Recommendation Report for Prior Notification

REF NO: LU/247/25/PD

LOCATION: 78 A High Street
Littlehampton
BN17 5DX

PROPOSAL: Prior approval under Schedule 2, Part 3, Class MA for the change of use from a business (Class E) to 1 No flat (C3).

Total Area for flat 3.62*2.90
=10.49 m2 4.56*1.95= 8.9m2
4.1*2.1=8.61 m2 3.63*2.62= 9.5
m2= 37.5M2

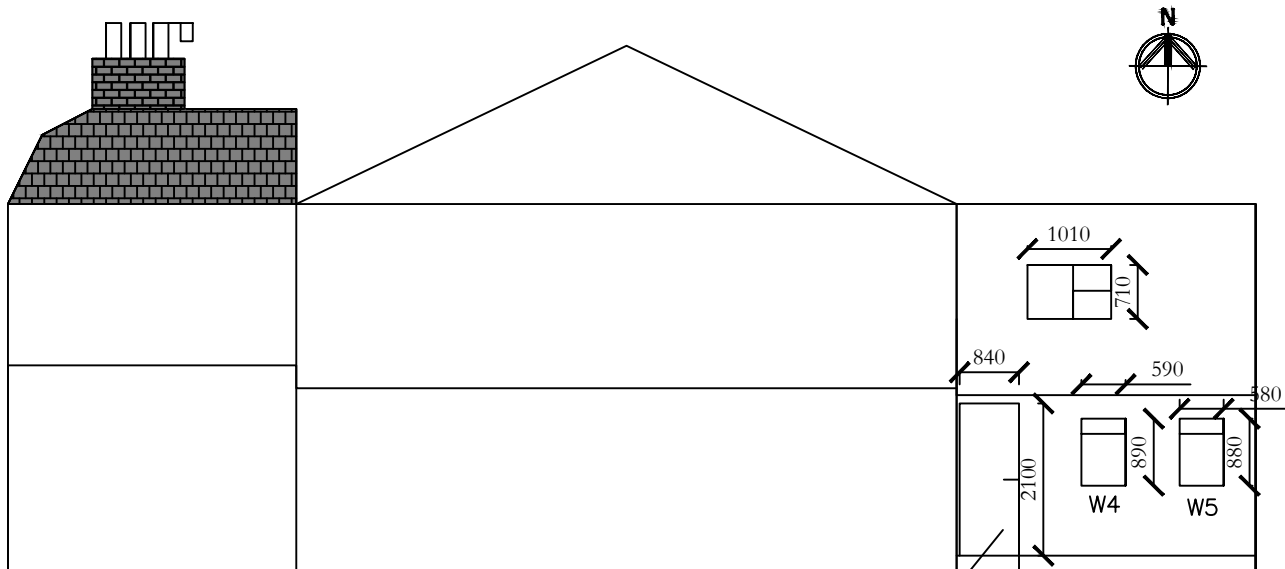
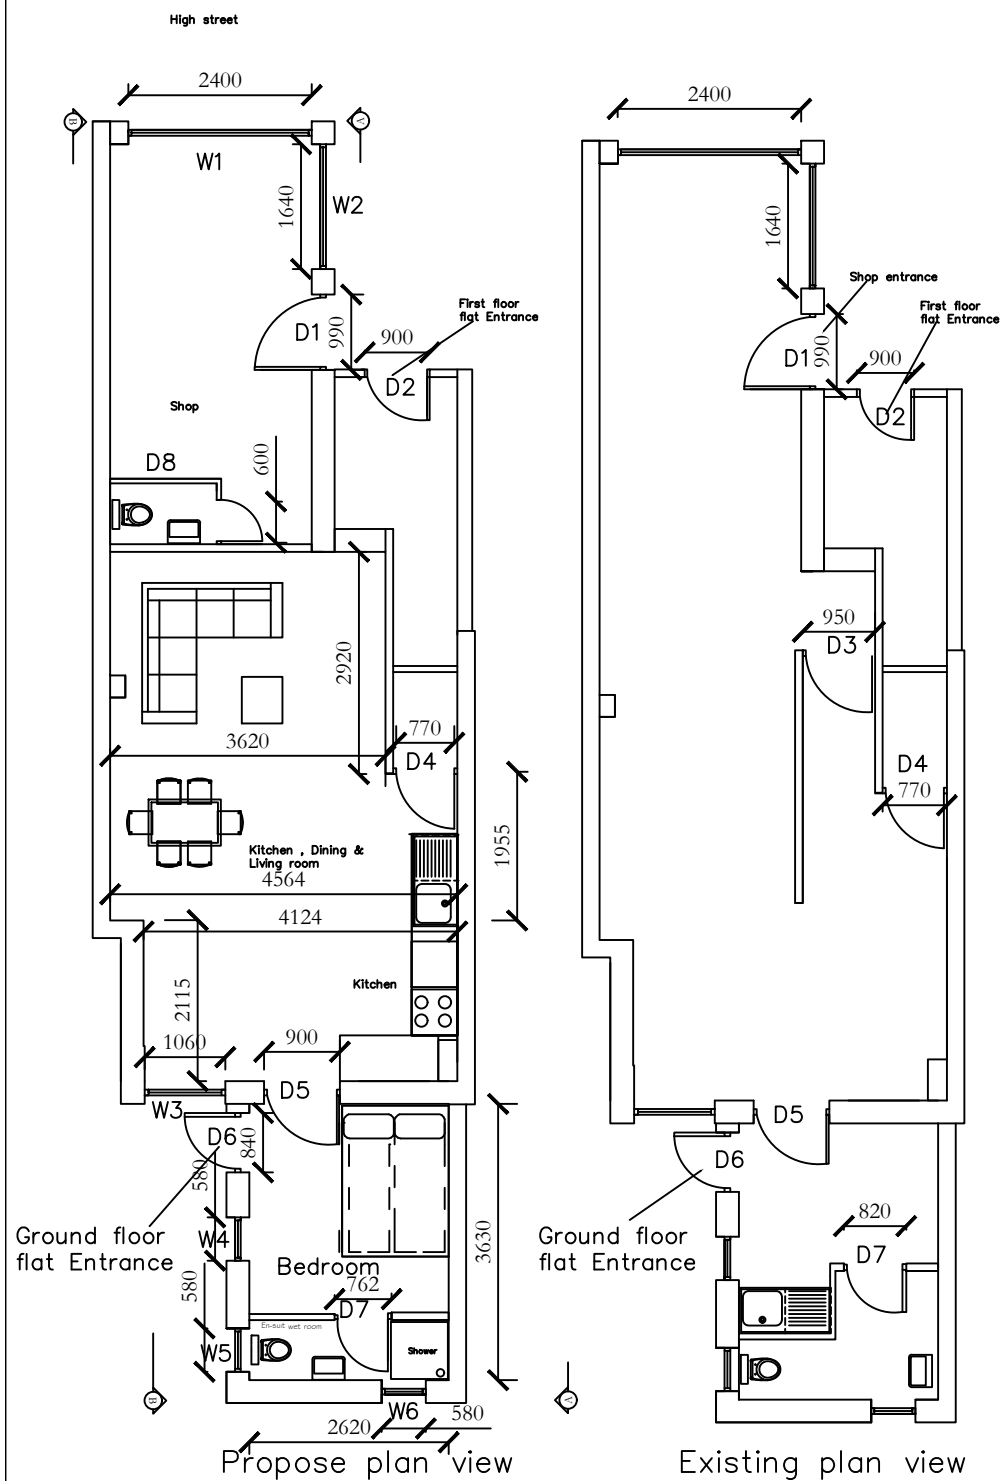
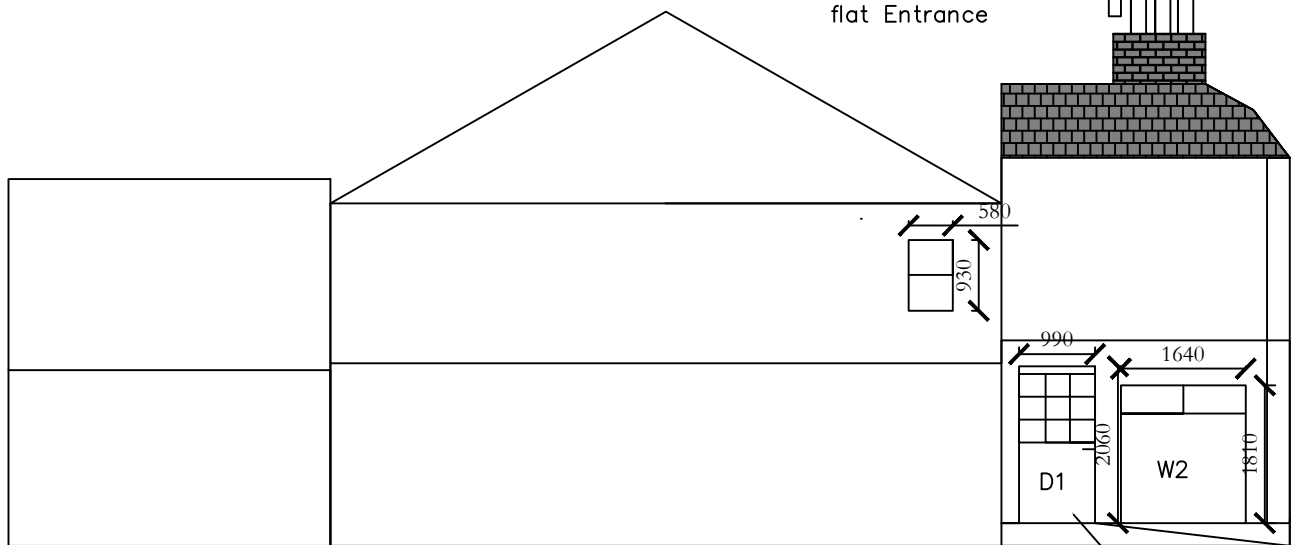
The plans demonstrate that the bedroom would have a window and there would be one window serving the open plan kitchen, living, dining room. Whilst this may not provide much natural light within the main living space, it does nonetheless comply with the requirements.

The unit provides 37.5sqm of floor space and the proposal complies with this requirement.
